**Reference No:** 2017/62/93430/W

**Site Address:** 11, Foster Avenue, Crosland Moor, Huddersfield, HD4 5LN

**Description:** Erection of single storey rear extension and detached double garage

## Officer Report

FLOOR PLAN OF GARAGE AS PROPOSED

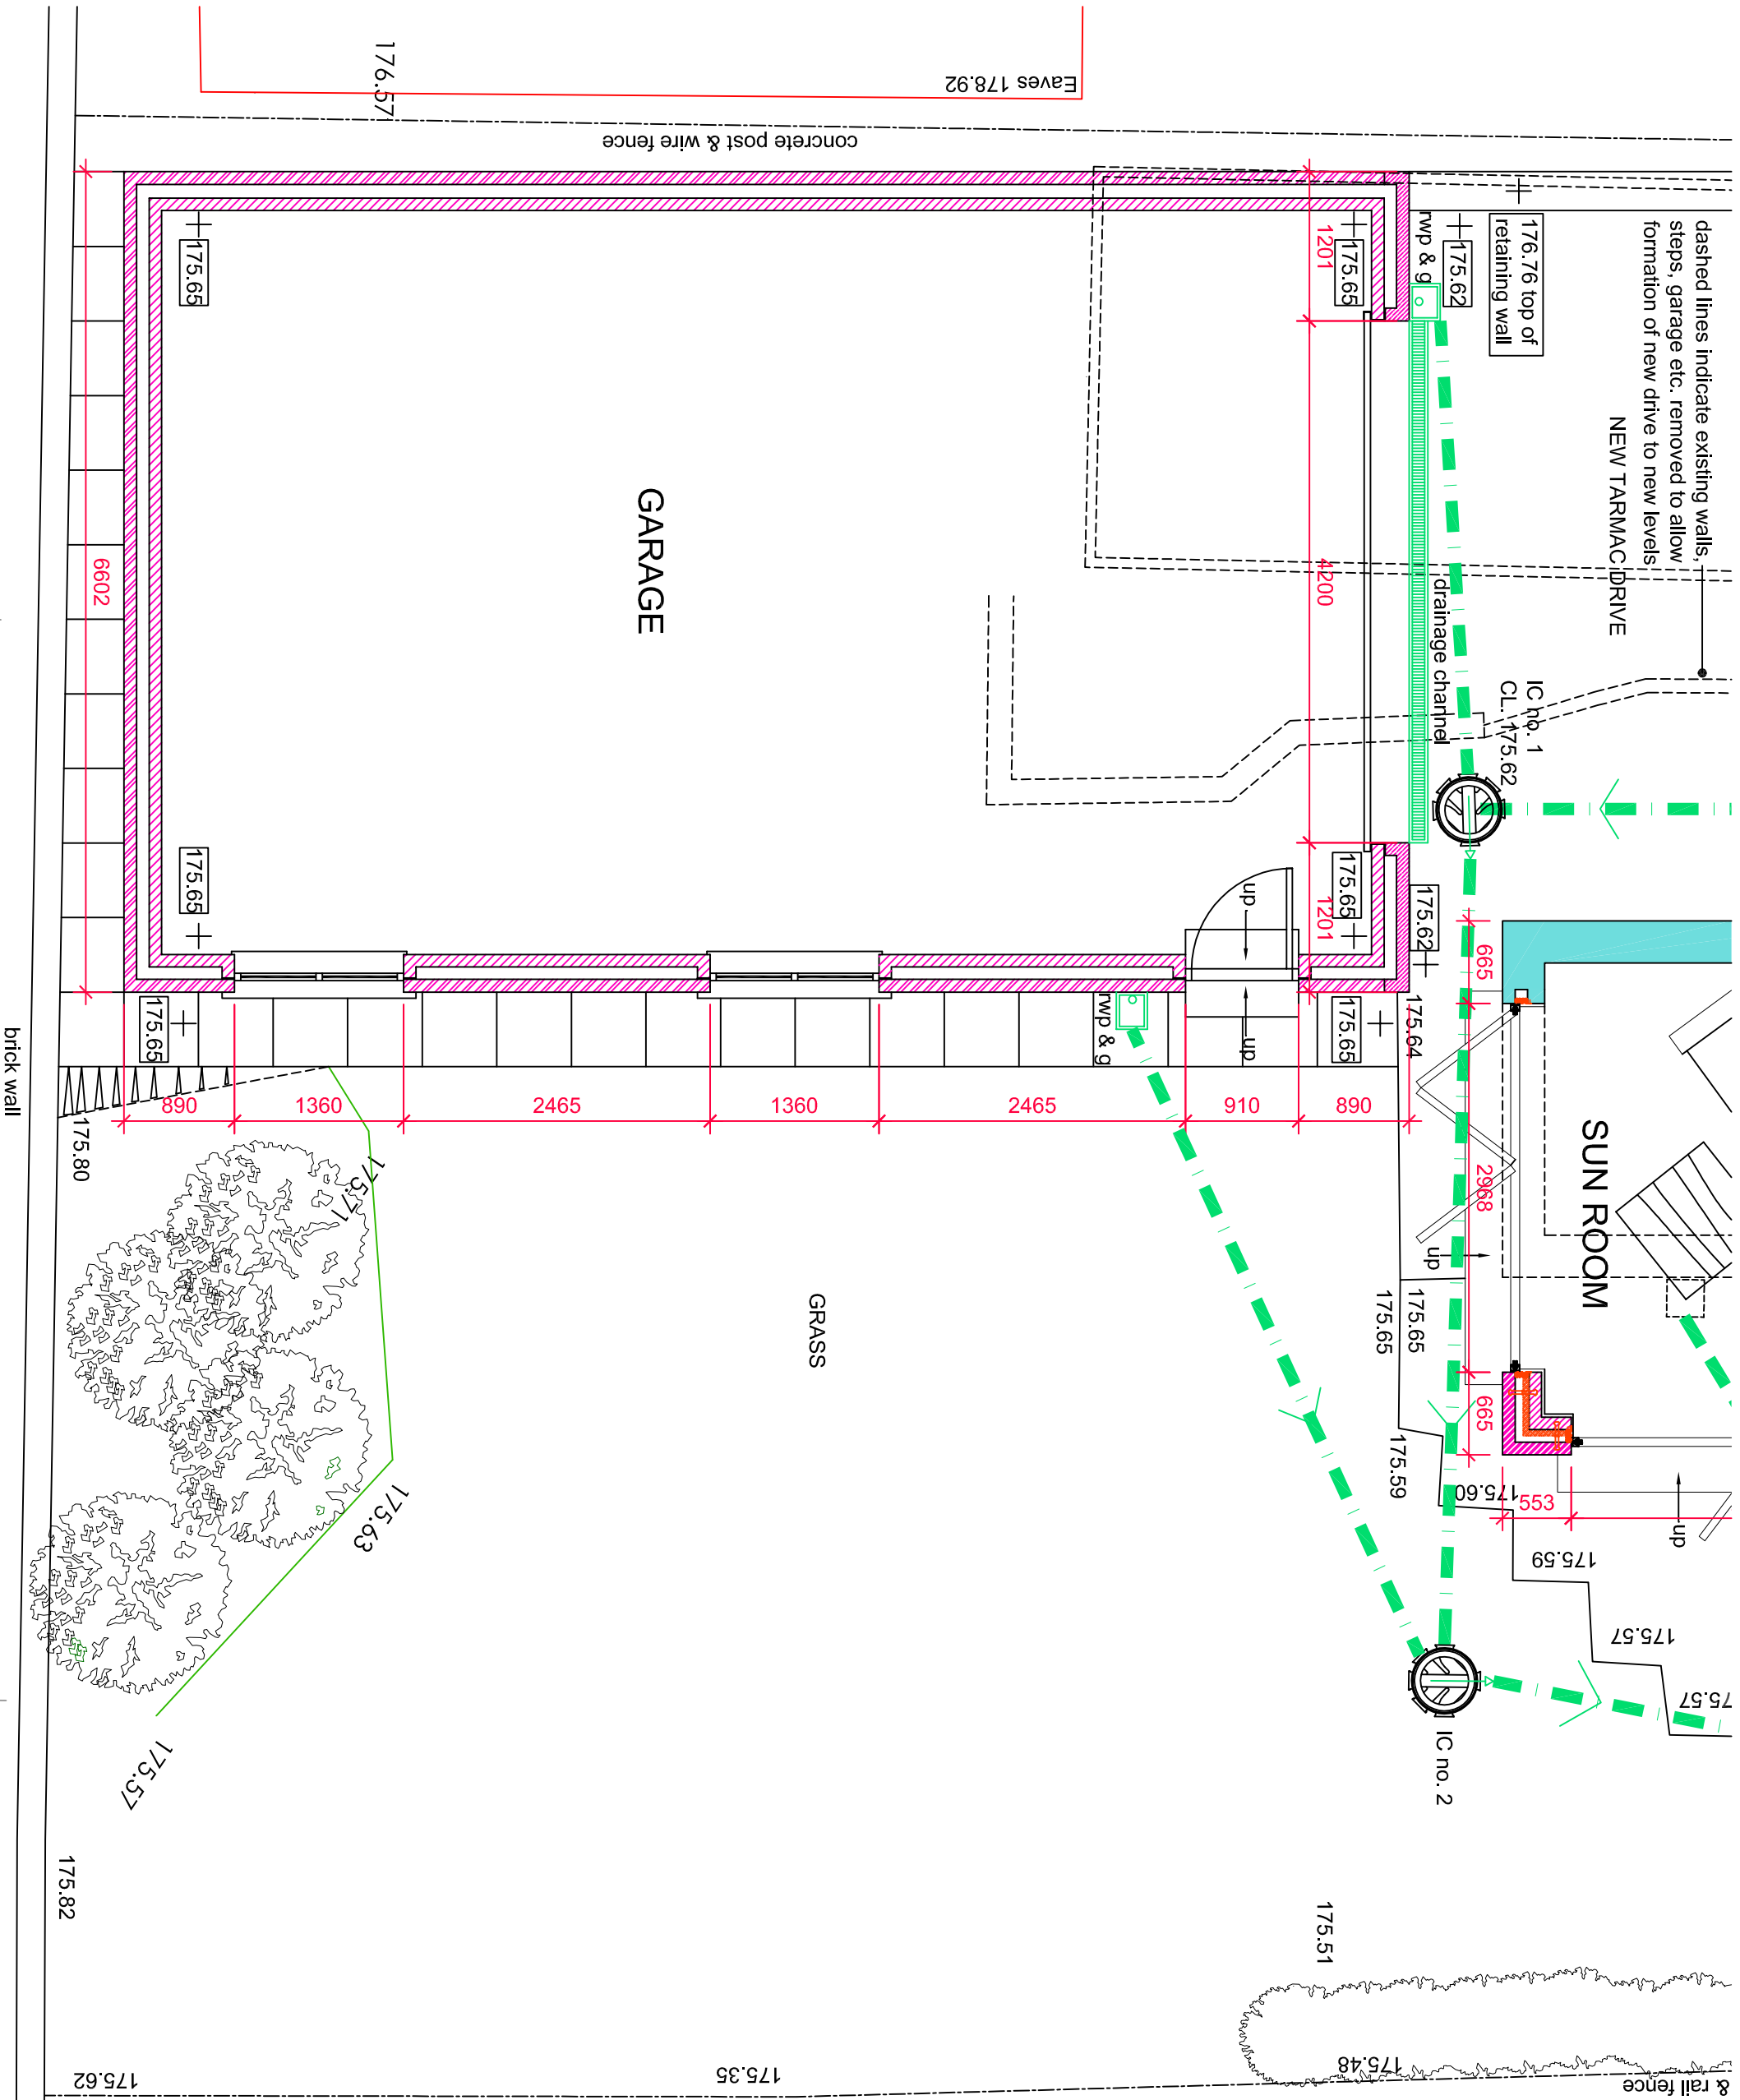
- These plans show a brick wall behind where the rear end of the garage will be sited which is number 24's boundary. There is also a trellis fence which is our boundary with number 11 Foster Avenue. Our only concern is therefore about the siting of the garage and the effect of the building work on our fence as the back of the garage appears to be very close to this. We would however have no objection to them replacing the fence with a wall of similar height to the one at number 24.

- These plans show a brick wall behind where the rear end of the garage will be sited which is number 24's boundary. There is also a trellis fence which is our boundary with number 11 Foster Avenue. Our only concern is therefore about the siting of the garage and the effect of the

building work on our fence as the back of the garage appears to be very close to this. We would however have no objection to them replacing the fence with a wall of similar height to the one at number 24.

**Response:** Amendments have been sought to reduce the scale of the proposed detached double garage. The amendments mean that the garage would no longer be built close to the boundary with no.26 or no. 24 therefore the building works would not have any impact on the boundary trellis fence.

LAYOUT OF NEW DRIVE

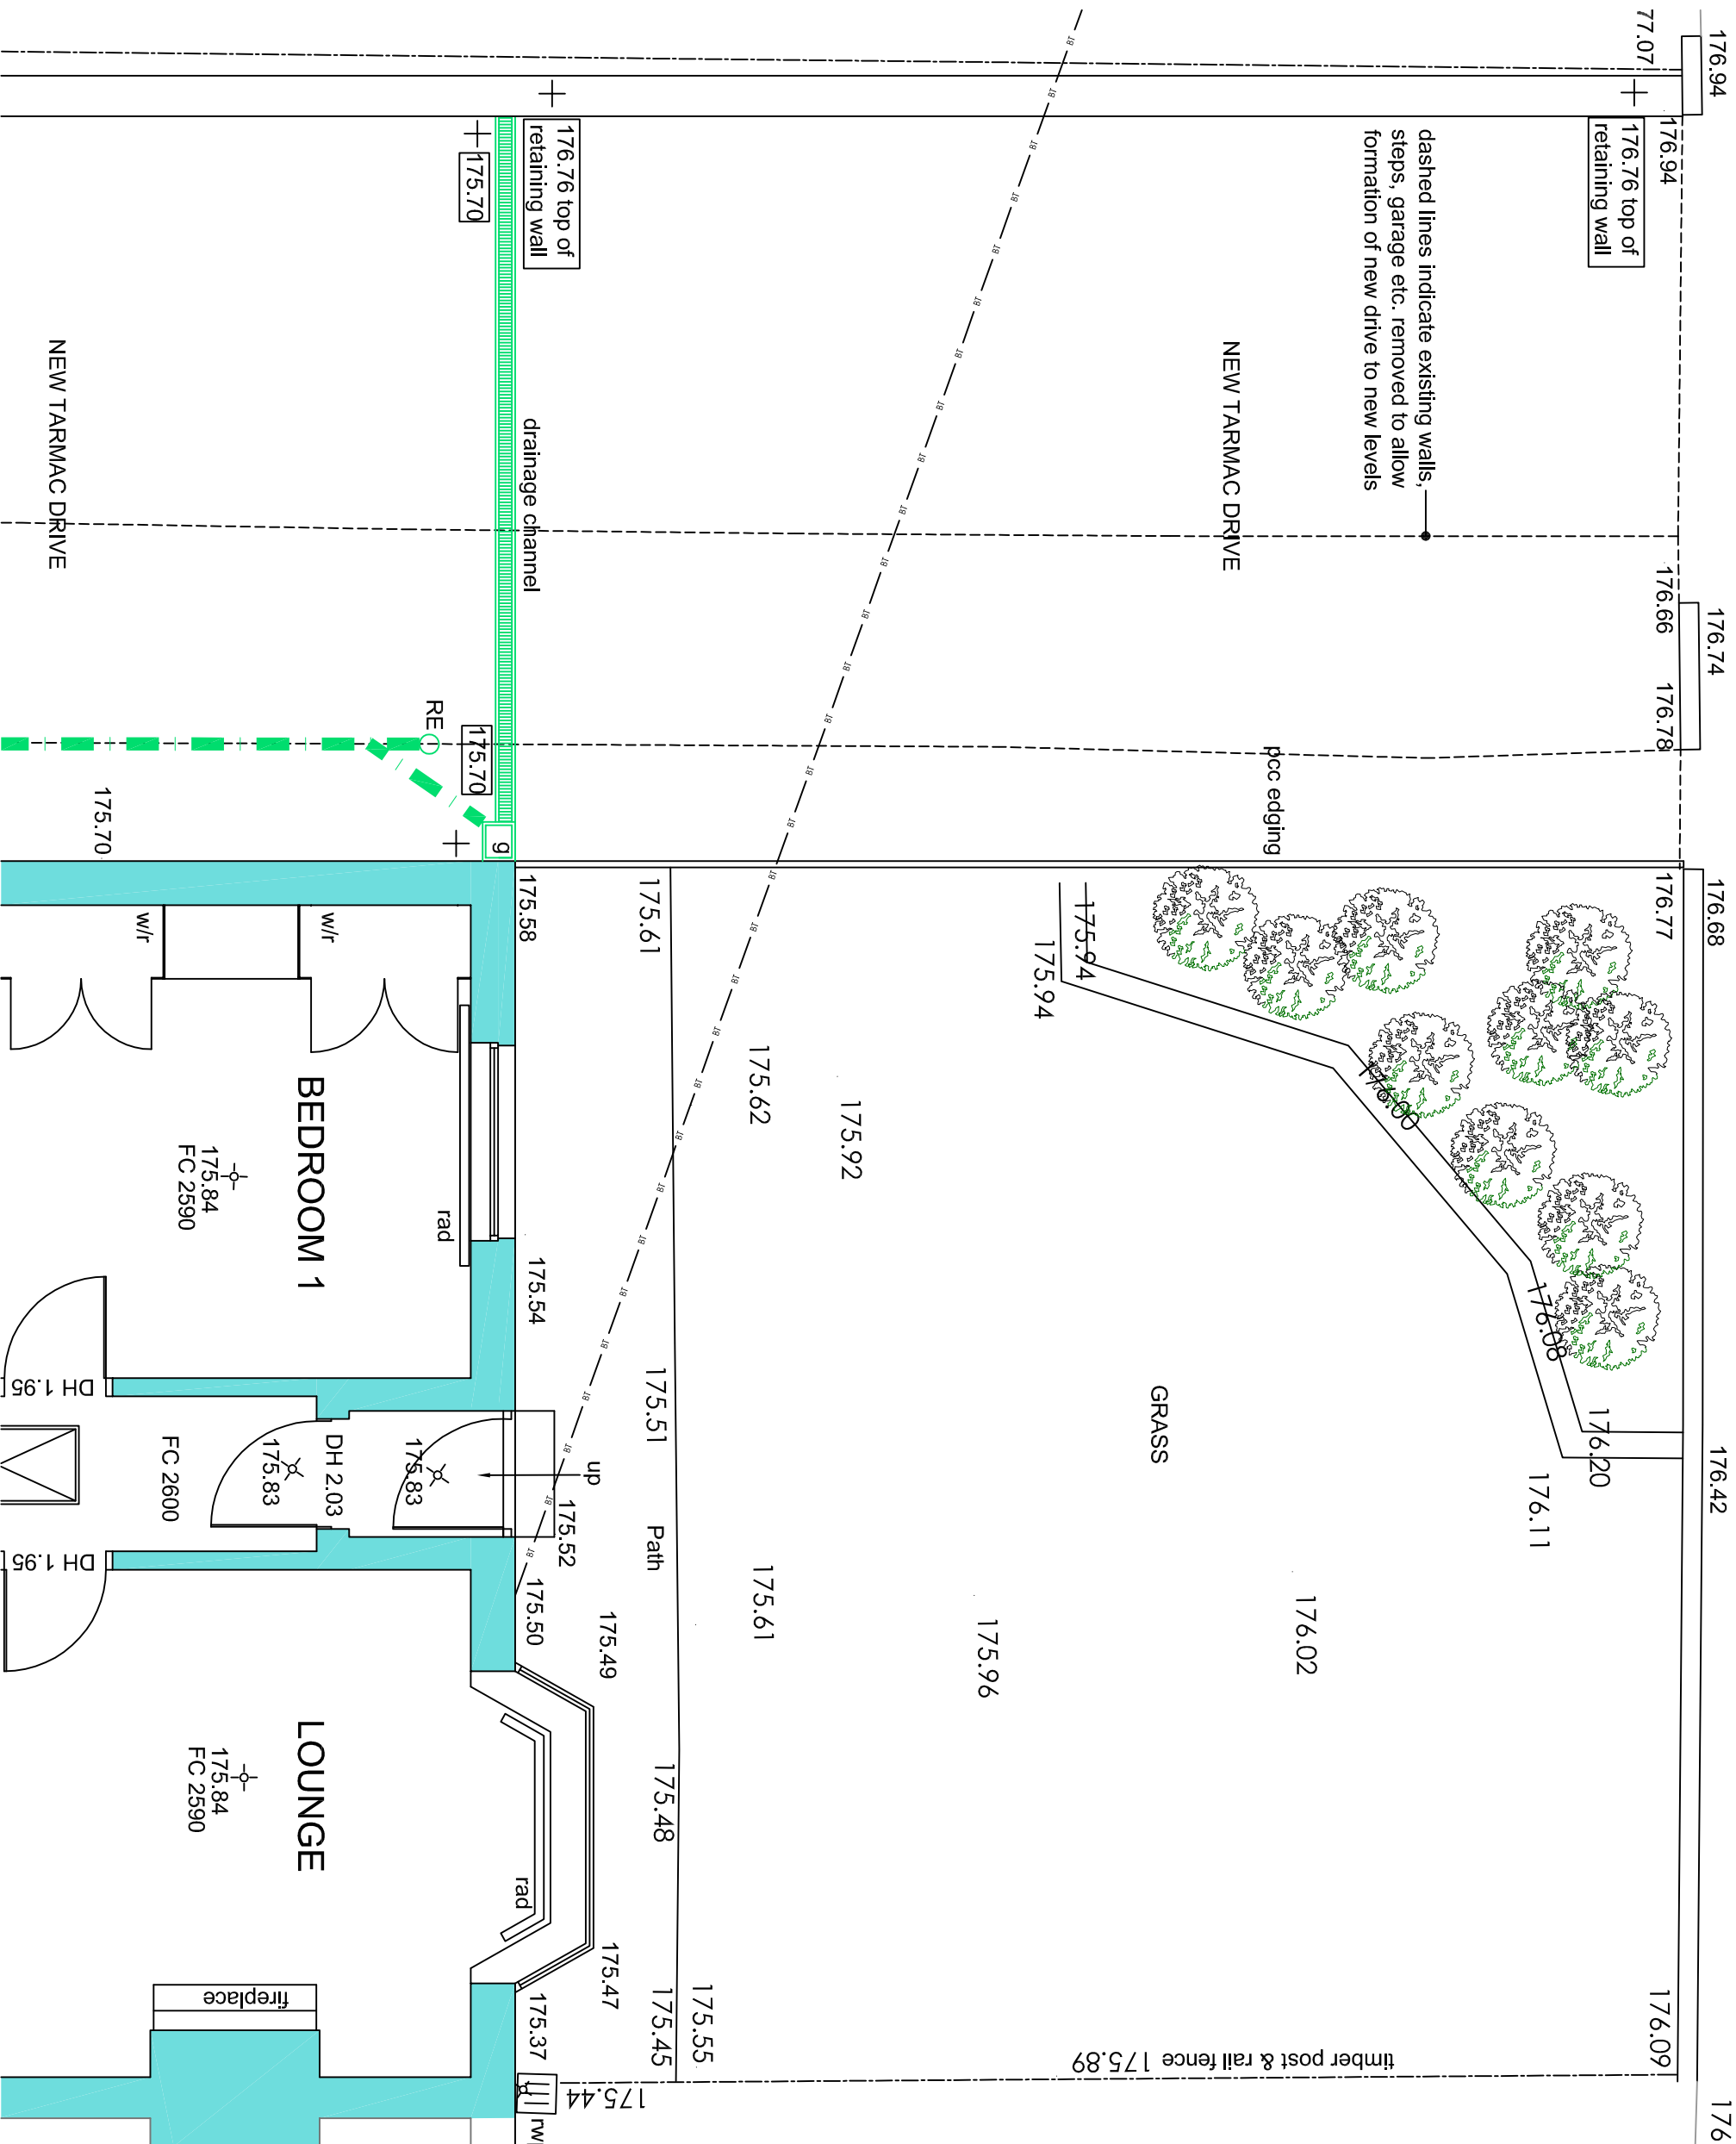
It is considered that the proposed extension and detached double garage will not represent overdevelopment of the site due to the spacious site the dwelling is situated within. The retaining wall to the south west to the new driveway should be faced in red brick to harmonise with the dwelling. Subject to this, the proposal complies with policies D2, BE1, BE13 and BE14 of the Unitary Development Plan, policies PLP1, PLP2 and PLP24 of the Publication Draft Local Plan, and chapter 7 of the NPPF.

The revisions to the driveway and access to the site will be undertaken on or close to a party wall and will involve the construction of a retaining wall to a maximum height of around 1.1m. Plans submitted show that the drive would include drainage channels and gently slope down towards the floor level of the new garage. In accordance with paragraph 120 of the NPPF it will be the landowners/developers responsibility for securing the safe development of the site. If a party wall is affected then this would be a private legal matter between the neighbouring properties to resolve through the Party Wall Act.

4. The new retaining wall to the driveway shall be faced in red brick to harmonise with that used in the host dwelling before the driveway is first brought into use. It shall thereafter be retained faced in red brick.
